APPENDIX A: RESPONSE TO SUBMISSIONS

Department of Planning and Environment (5/8/17)	WPG Response
1	<p>Design Excellence</p> <p>Provide further consideration of how the building/s exhibit design excellence in accordance with the specific requirements of Schedule 3, Part 23, clause 30(2) of <i>State Environmental Planning Policy (State Significant Precincts) 2005</i>.</p>	<p><u>Siting and design of the buildings:</u></p> <p>The orientation and form of the buildings is a direct response to the careful positioning of the major component of the proposal, being the surfing lagoon. Instead of clumping the buildings in one area, they have been wrapped and splayed to provide a curvaceous built form around the shoreline, which constitutes the longest edge of the lagoon (and the premium spectator area). This curved built form design strengthens the facility's visual amenity and operational coherence by maximising site activation, connecting guest and service areas, and effectively reducing the need for unsightly fences or barricades.</p> <p><u>Materiality and detail:</u></p> <p>The materials selected convey a sense of down-to-earth simplicity and integrity. "Cosmetic" finishes will be avoide

DIMENSION PLAN			
DRAWING NO.	DRAFTER	CHECKED	REV.
DA.13 A	LP	MM	D

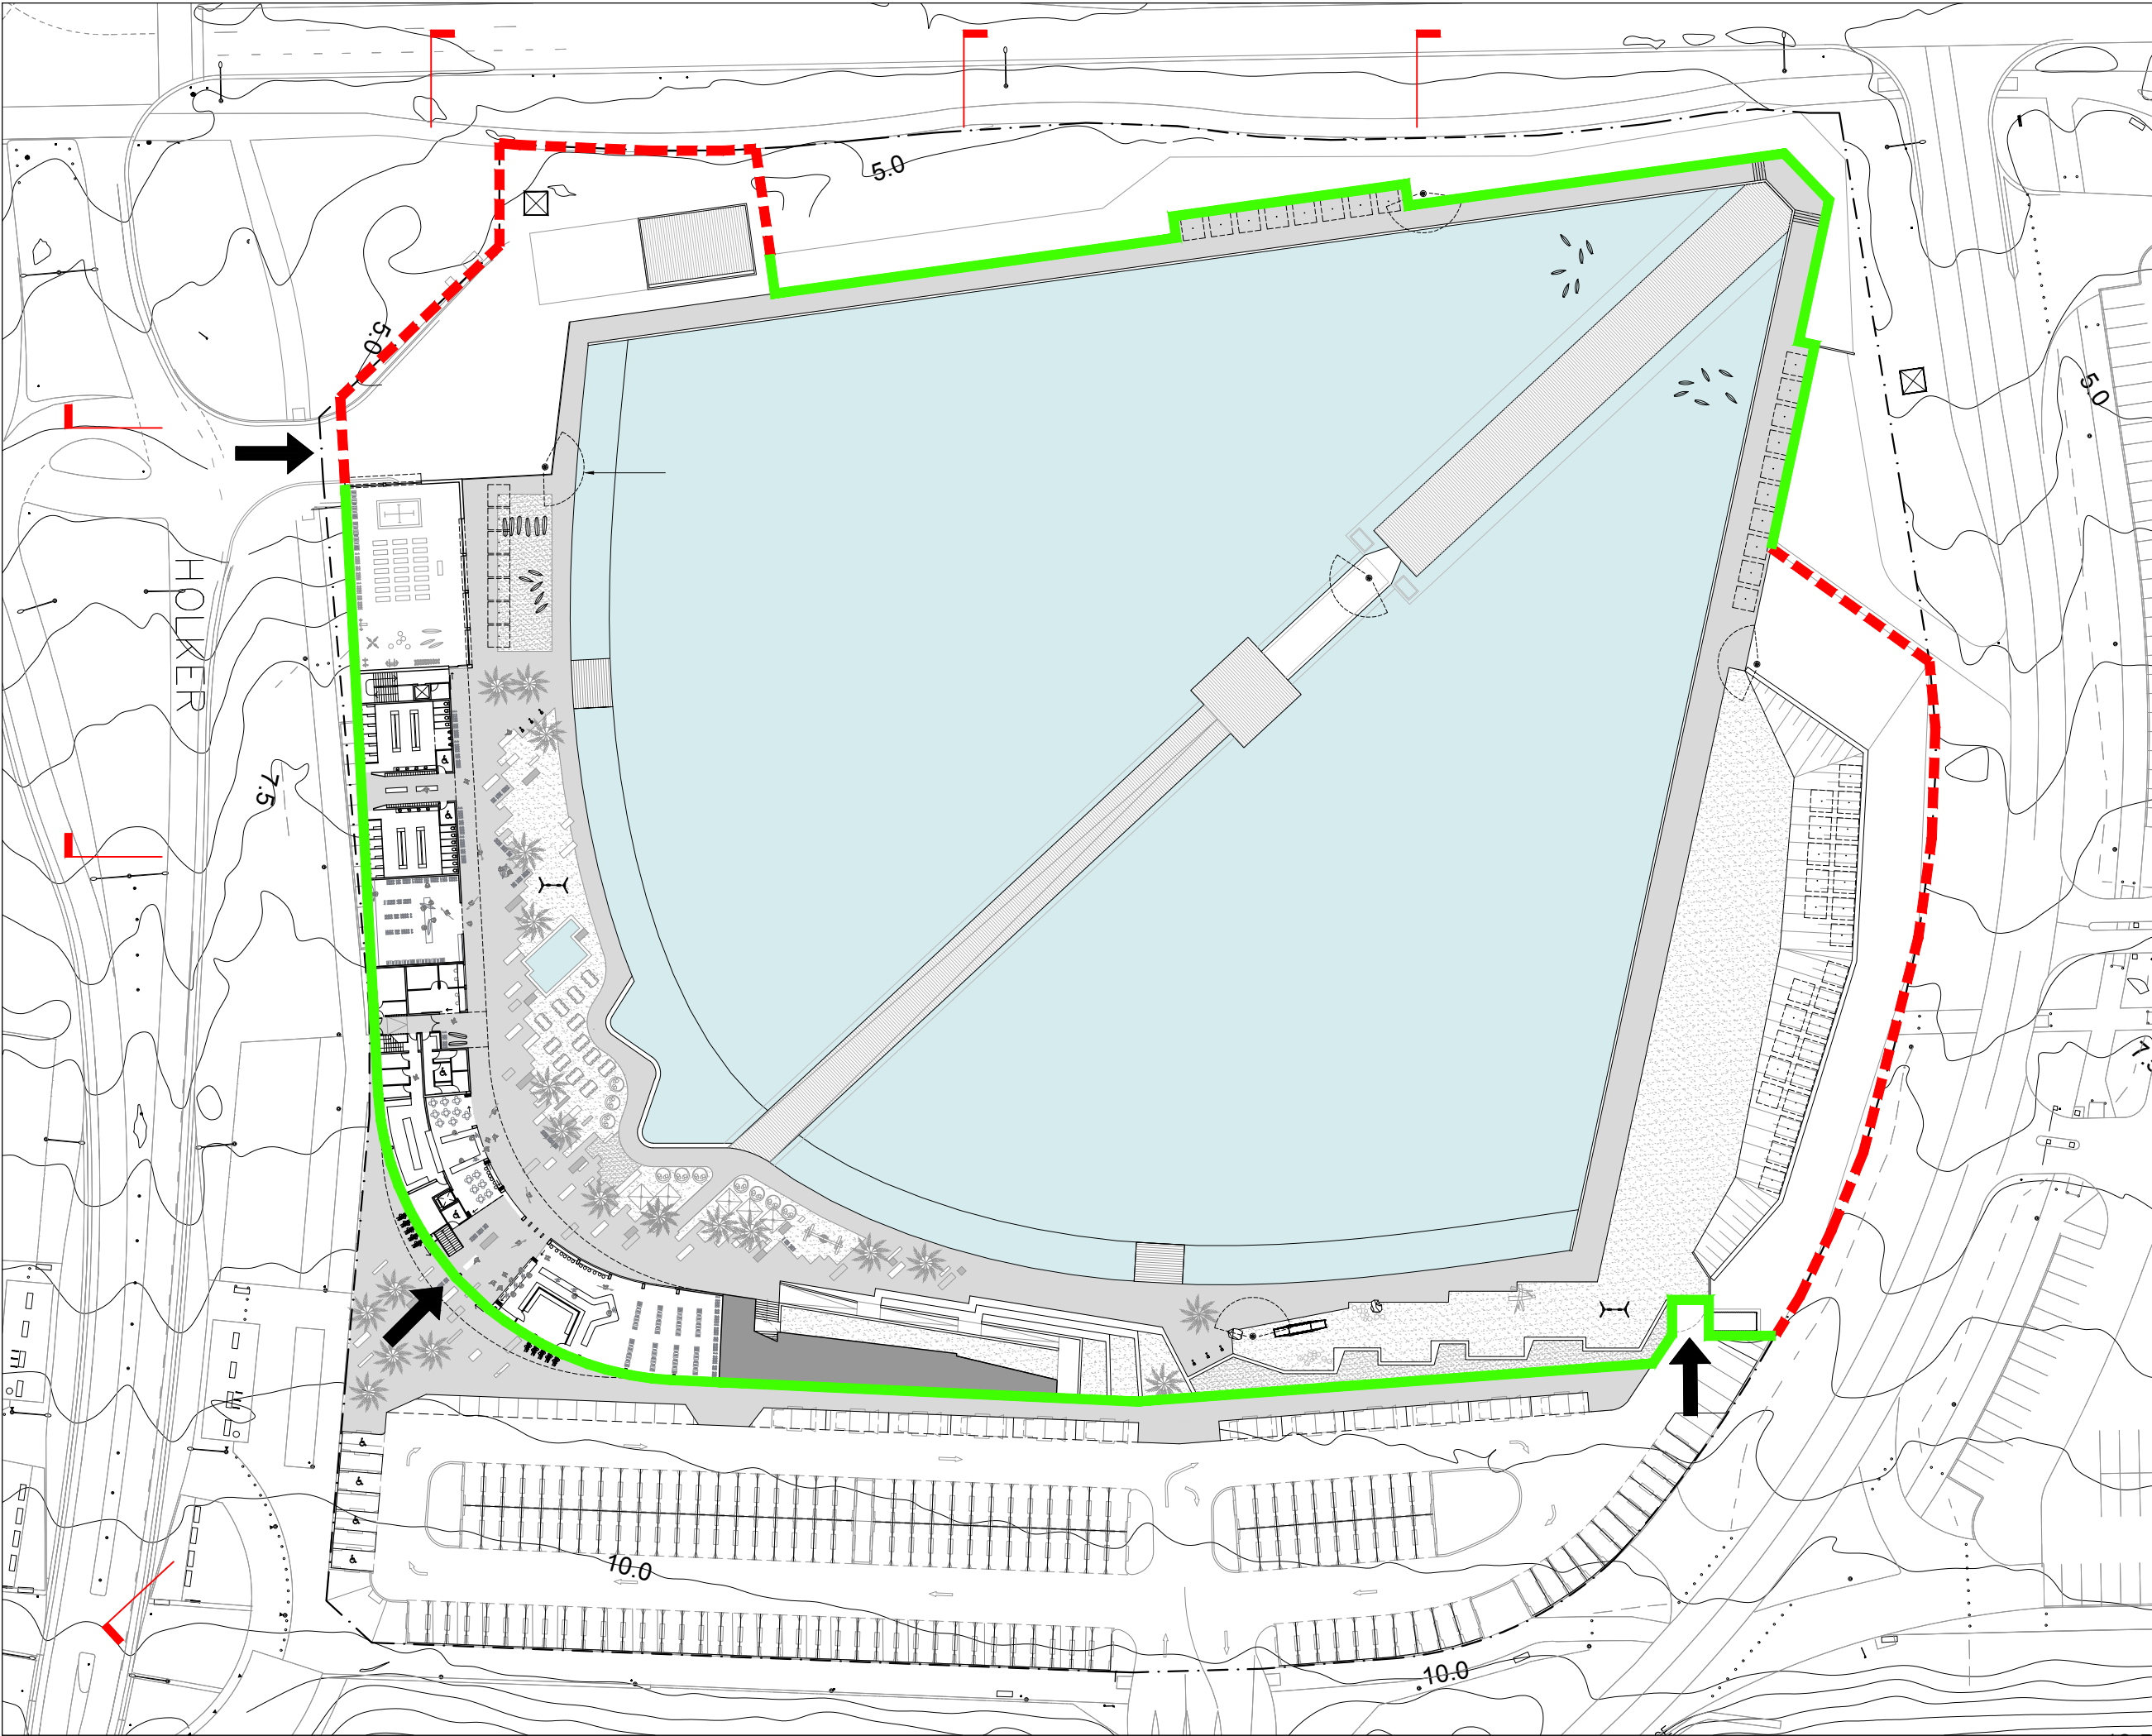
3	<p>Building Parameters</p> <ul style="list-style-type: none"> Provide clarification of the approximate width, length and height (expressed as above ground level and RL) of the pier and wave generator structures noting inconsistencies in EIS and accompanying architectural plans. 	<p>Please refer to the updated architectural drawings for correct dimensions and as the priority document in respect of any inconsistencies.</p> <p>The approximate width and length of the wave generator is shown on plan DA13A. RLs are shown in plans DA21 to 25 inclusive.</p>
4	<p>Structural Details and Safety</p> <p>a) Provide details demonstrating the proposal will comply with the Building Code of Australia.</p>	<p>a) Please refer to the Preliminary NCC BCA Report prepared by CODE in Attachment 5 demonstrating compliance with the Building Code of Australia.</p>

DRAWING NO.	DRAFTER	CHECKED	REV.
DA.09	LP	MM	D

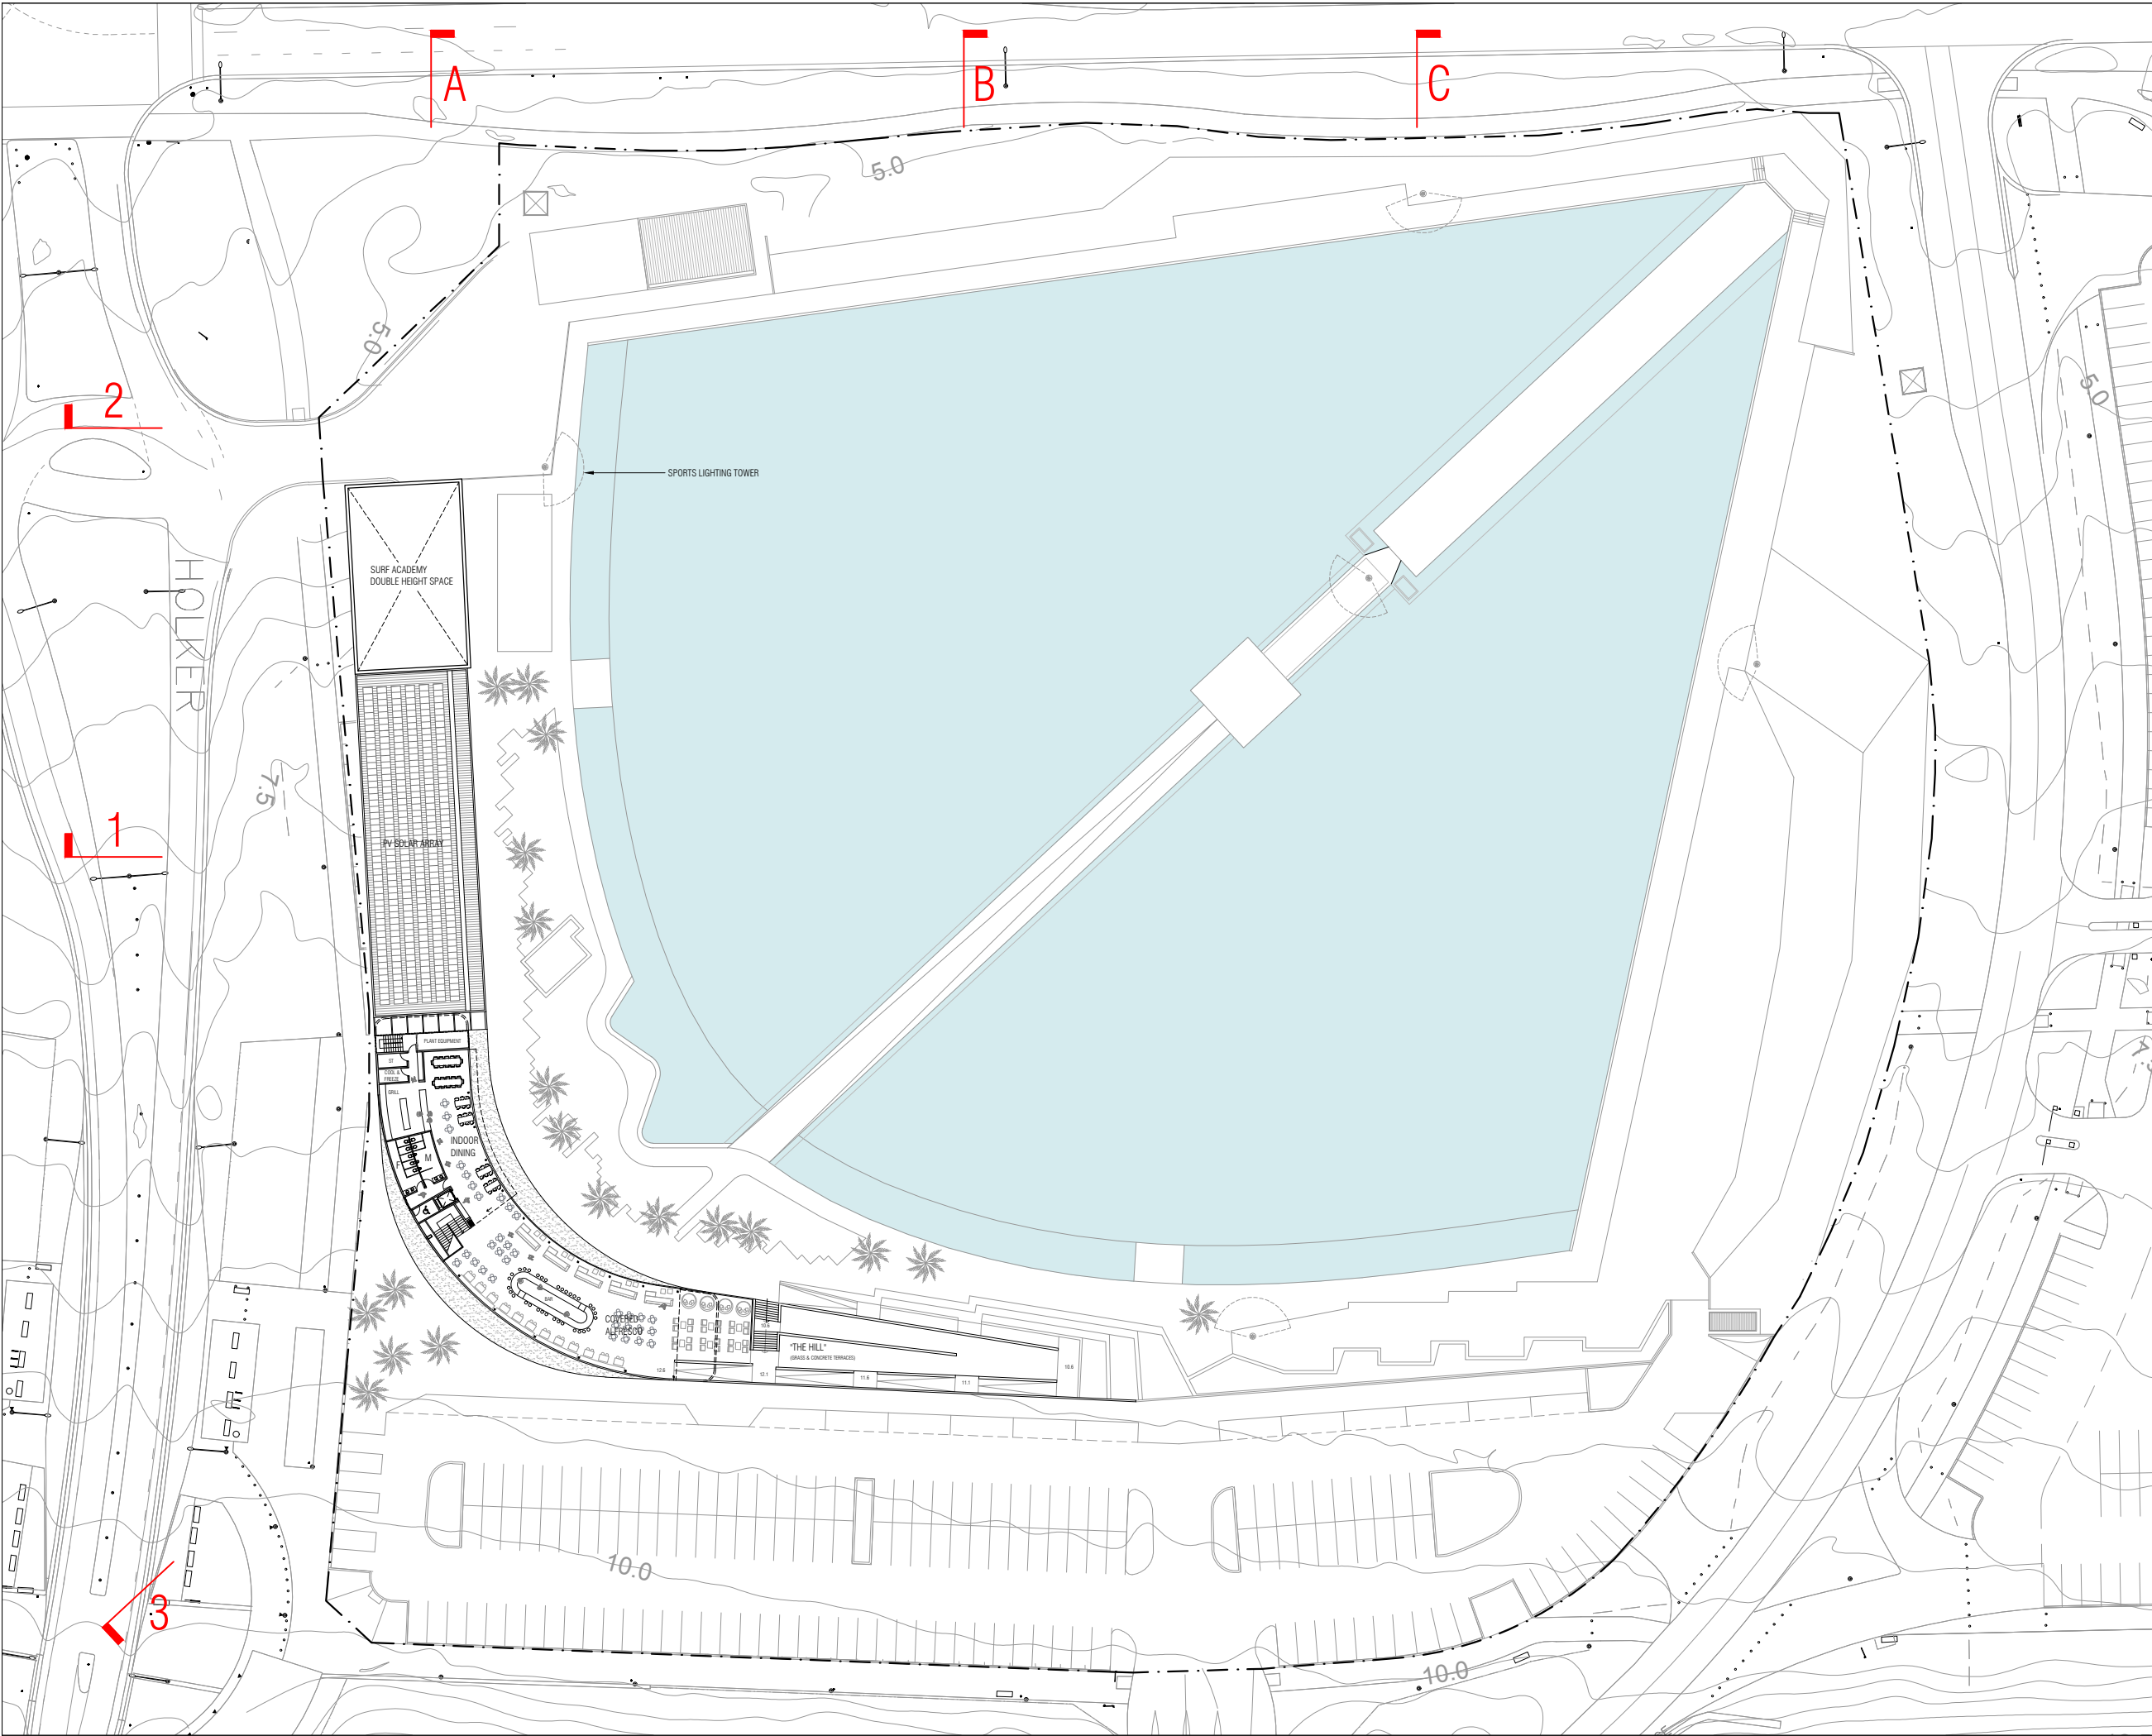
Confirm the combined GFA of all buildings on site and the total site area (noting some inconsistencies on this in the EIS).	Please refer to the updated Architectural Drawings (page 11) noting the GFA of all buildings, being 1,669sqm and the total site area being 36,766sqm.
---	---
